From: Ian Brewster
Sent: 07 April 2011 14:14
To: Janice Chapman
Subject: AW/59/11/T Kings Lodge 1 Kingsway Craigweil PO21 4DQ

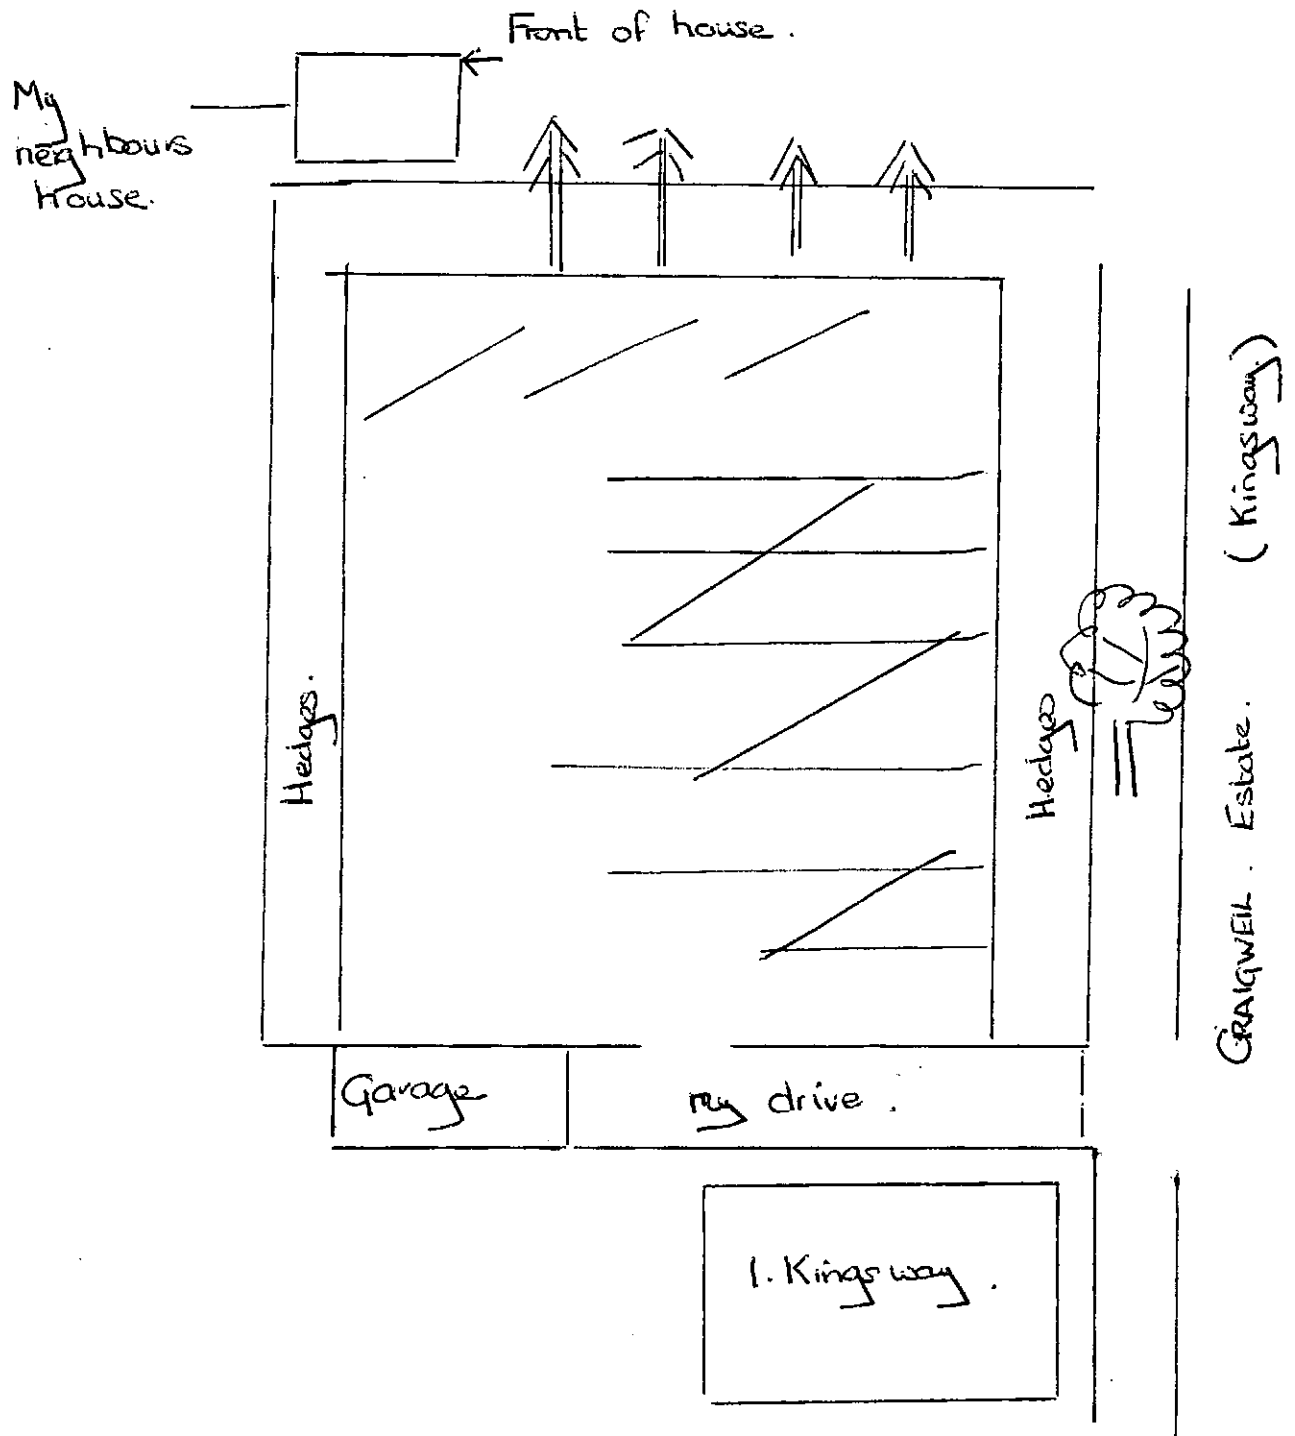
I have visited the above site and met with the lady occupant of the property who kindly showed me the Holly trees for reduction which are subject of this application. The reduction in height of the Holly to 12 feet (4m) is acceptable. However there is a young Oak tree within the Holly and has potential to become a prominent and suitable feature within the Kingsway locality, especially being near to the junction to the driveway. The applicant is now aware of this tree and it is recommended that it is retained, proud of the Holly.
